Recommendation Report for Approval of Reserved Matters Following Outline Approval

REF NO: BE/38/18/RES

LOCATION: Land to the rear of
17, 19, 21 & 23 Greencourt Drive
Bersted
PO21 5EU

PROPOSAL: Approval of reserved matters following outline consent BE/138/16/OUT for 2 No. dwellings

Client
Matt Lush
Drawing Title
Drainage Layout

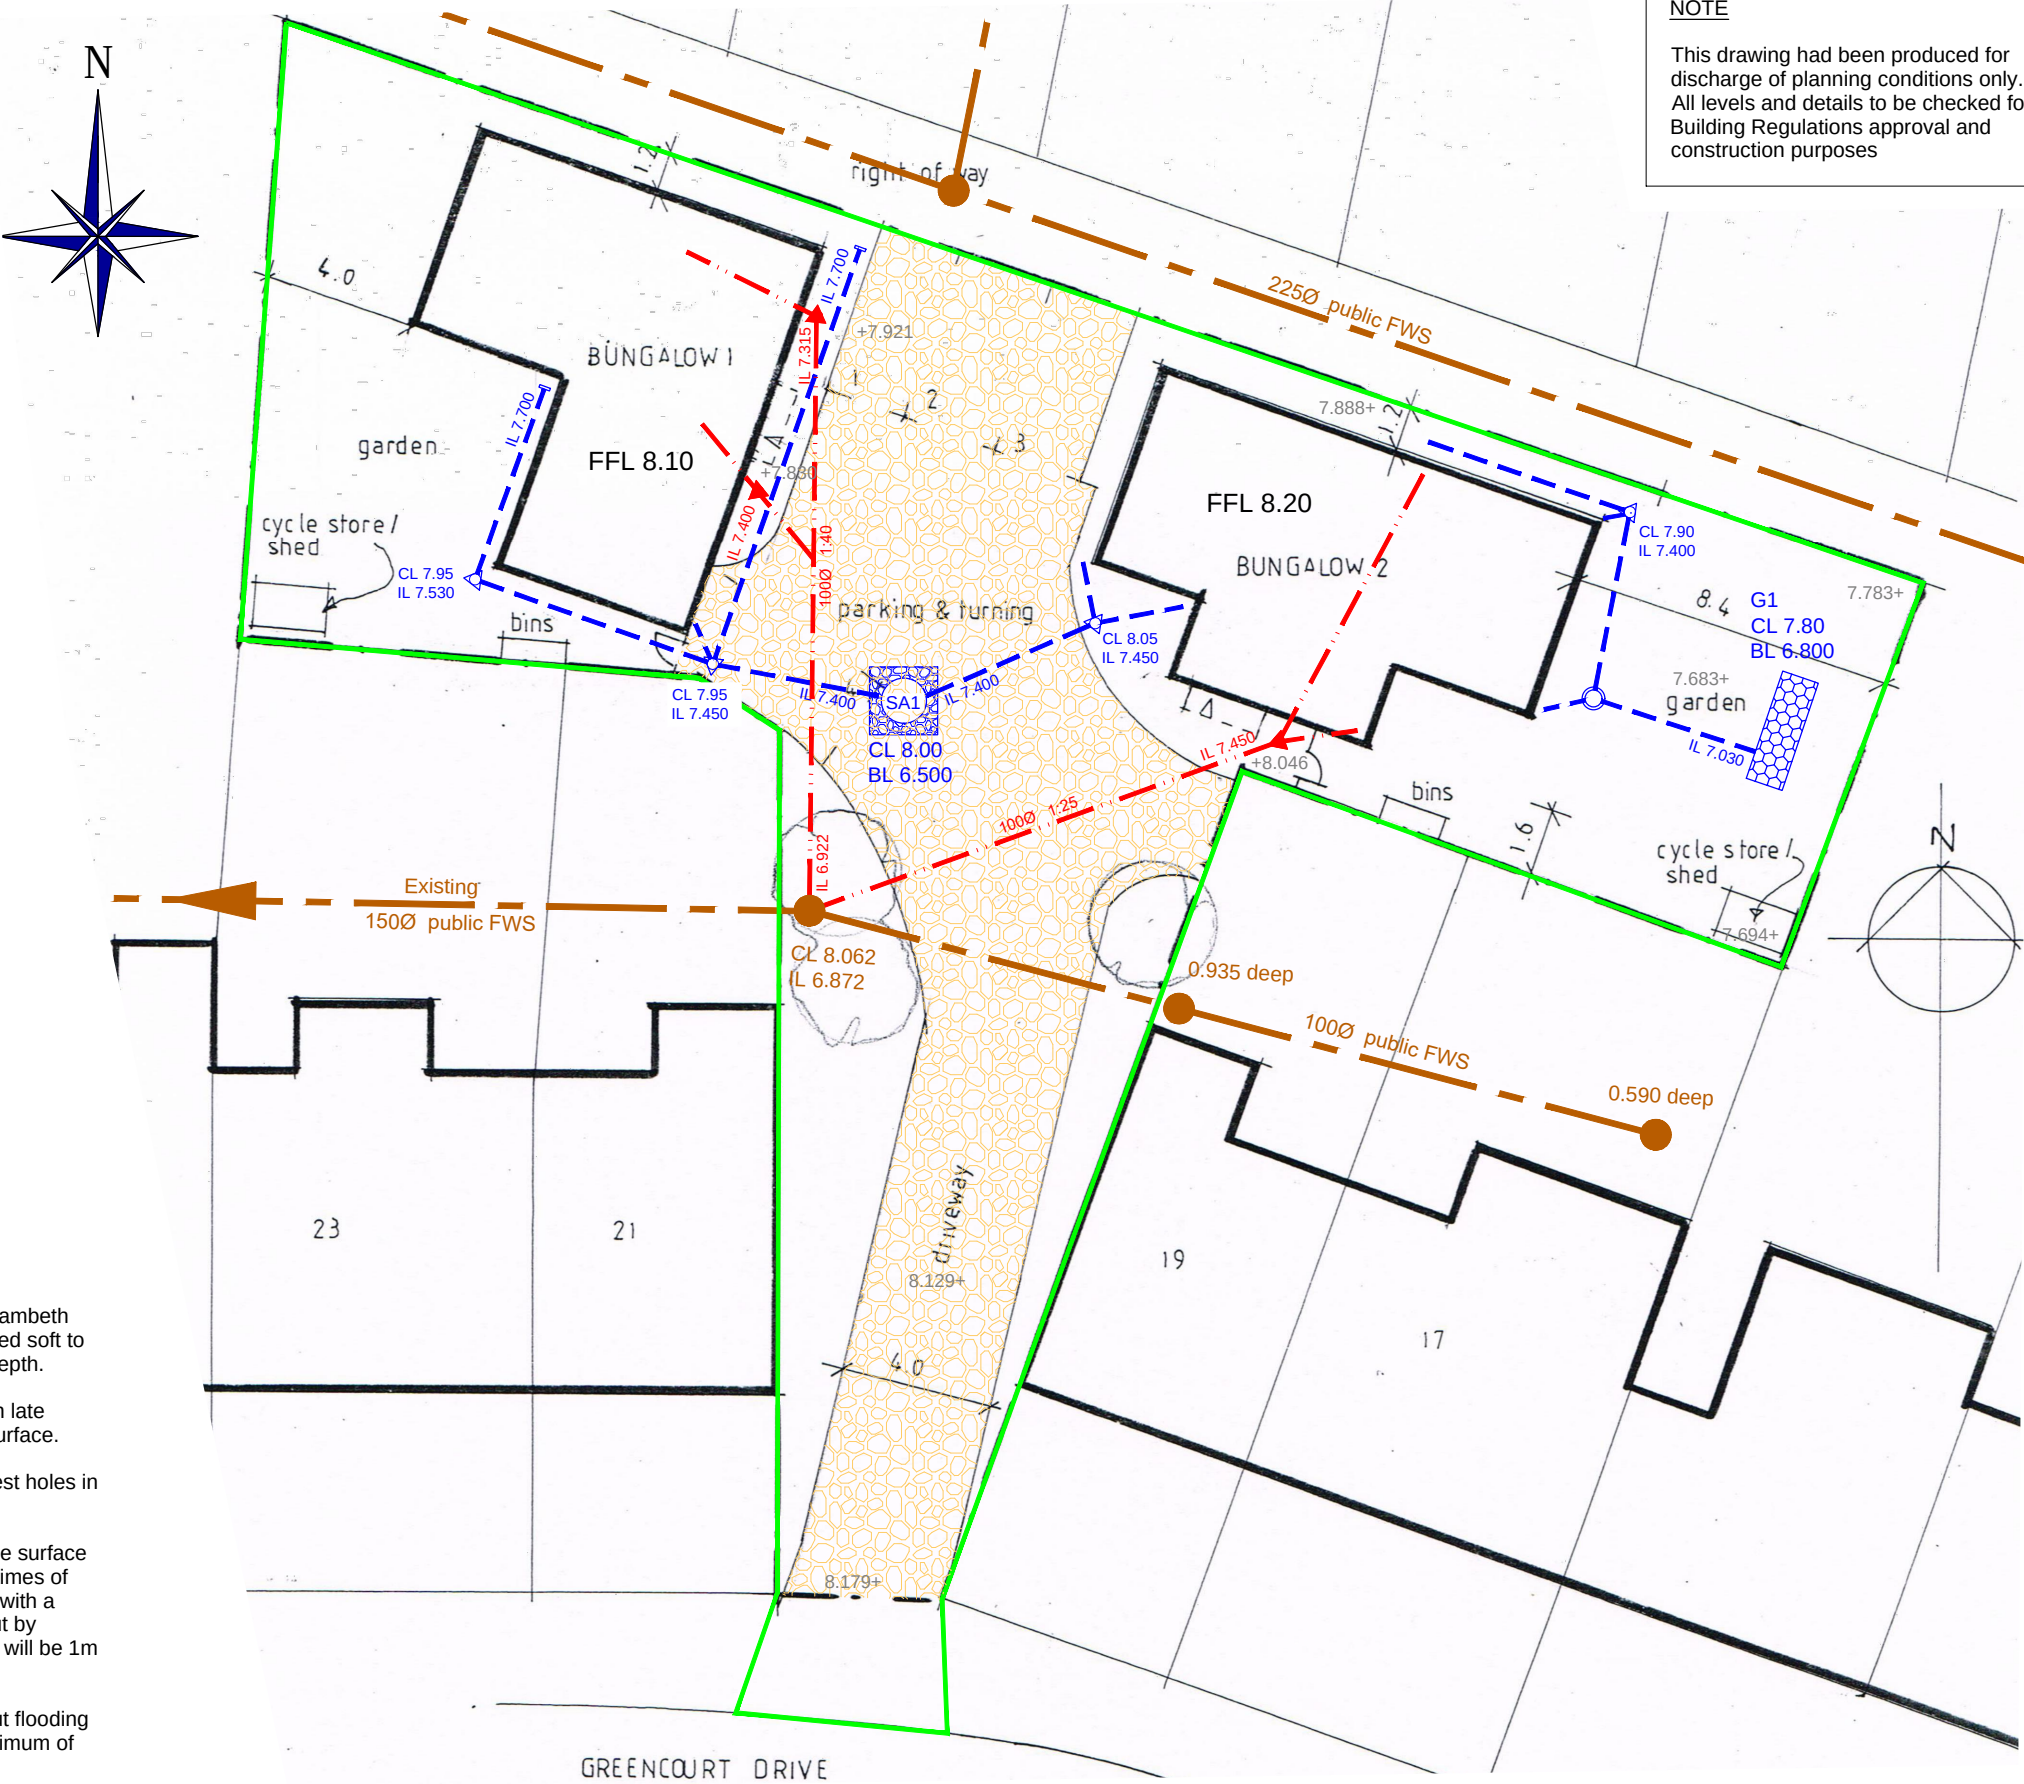
Engineers (Drainage) - ENGD2A applied to BE/138/16/OUT still stands. It is noted that the soakaway depth is 400mm, the maximum calculated water depth exceeds this, please revise before submitting DOC.
